**Planning Act 2008 – Application for a Development Consent Order for the  
Tillbridge Solar Project  
Applicant Response to Section 51 Advice letter dated 8 May 2024  
Application Ref: EN010142**

This letter sets out the Tillbridge Solar Limited's (the Applicant) response to those observations set out in the section 51 letter dated 8 May 2024.

FIGURE NUMBER
Figure 16-8

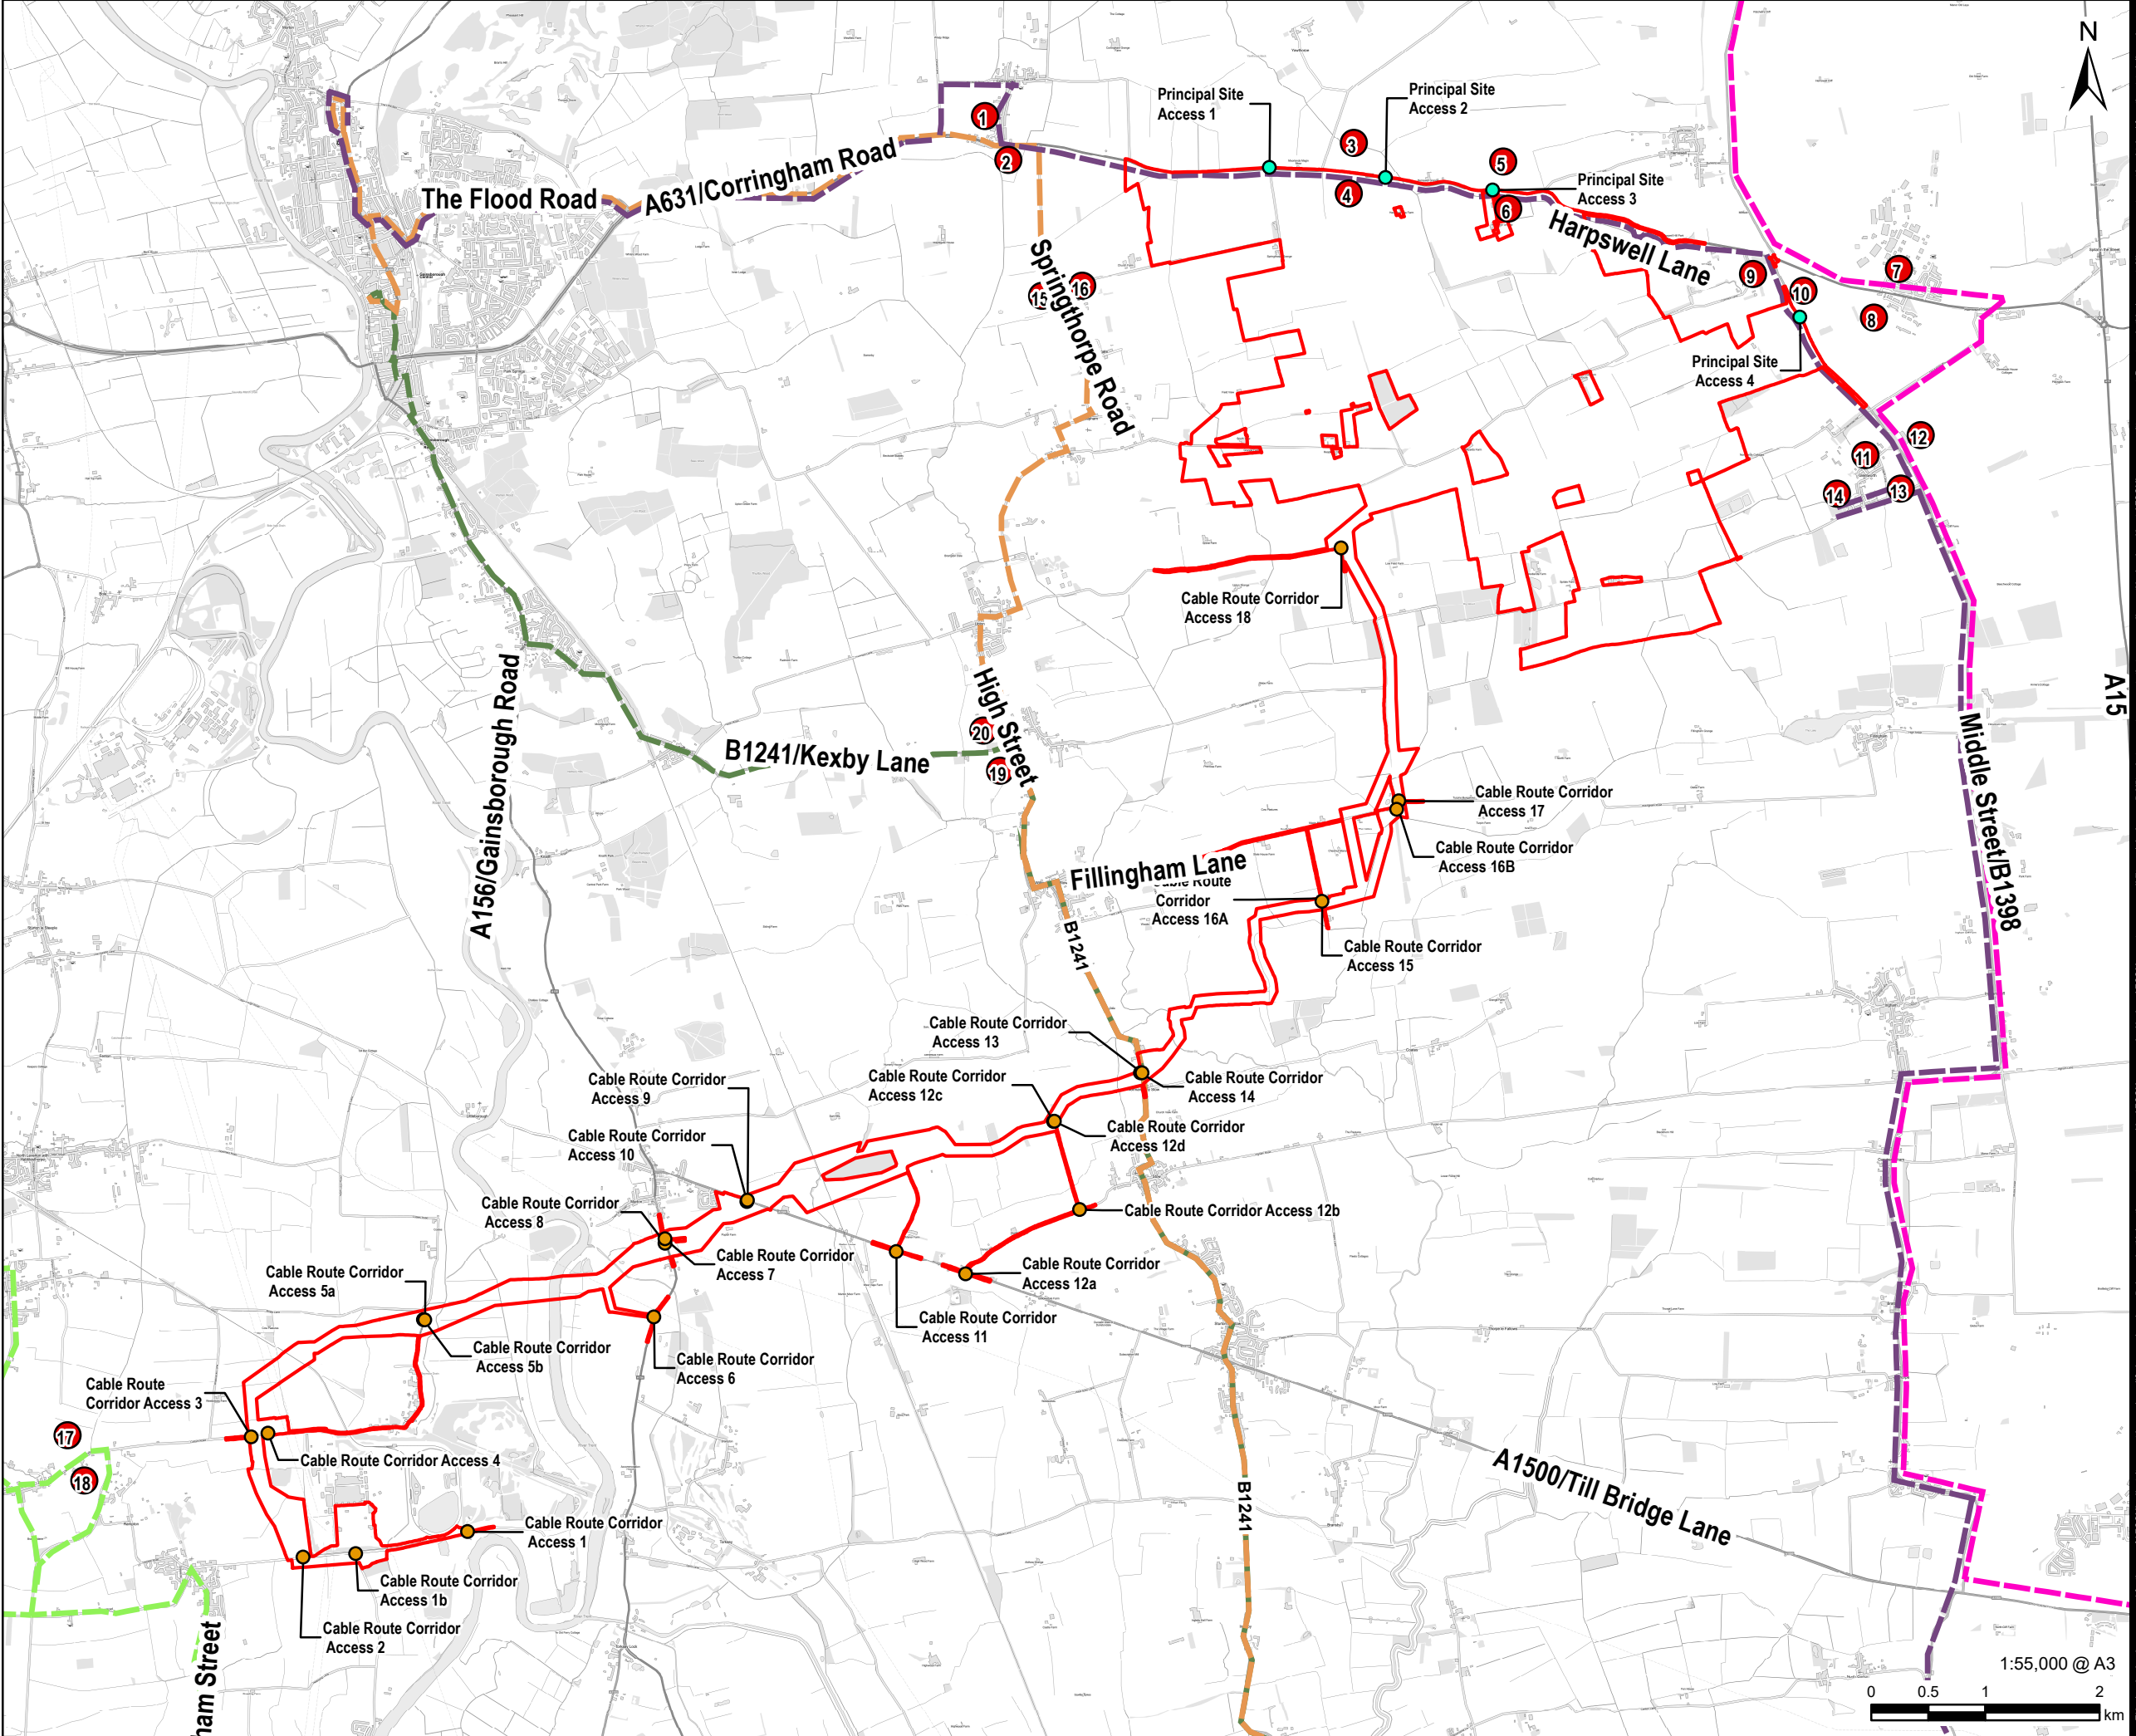
6.3	Figure 16-4 – Local Highway Network	
6.3	Figure 16-8 – Selected Bus Stops and Routes Closest to the Scheme	
6.4	ES Non-Technical Summary (tracked change version)	Document has been updated to include references to the standalone <b>Indicative Landscape Masterplan [EN010142/APP/7.19]</b> and to replace Figures 2 and 4, where the colour scheme had been updated in response to comments received from PINS on 8 May 2024.
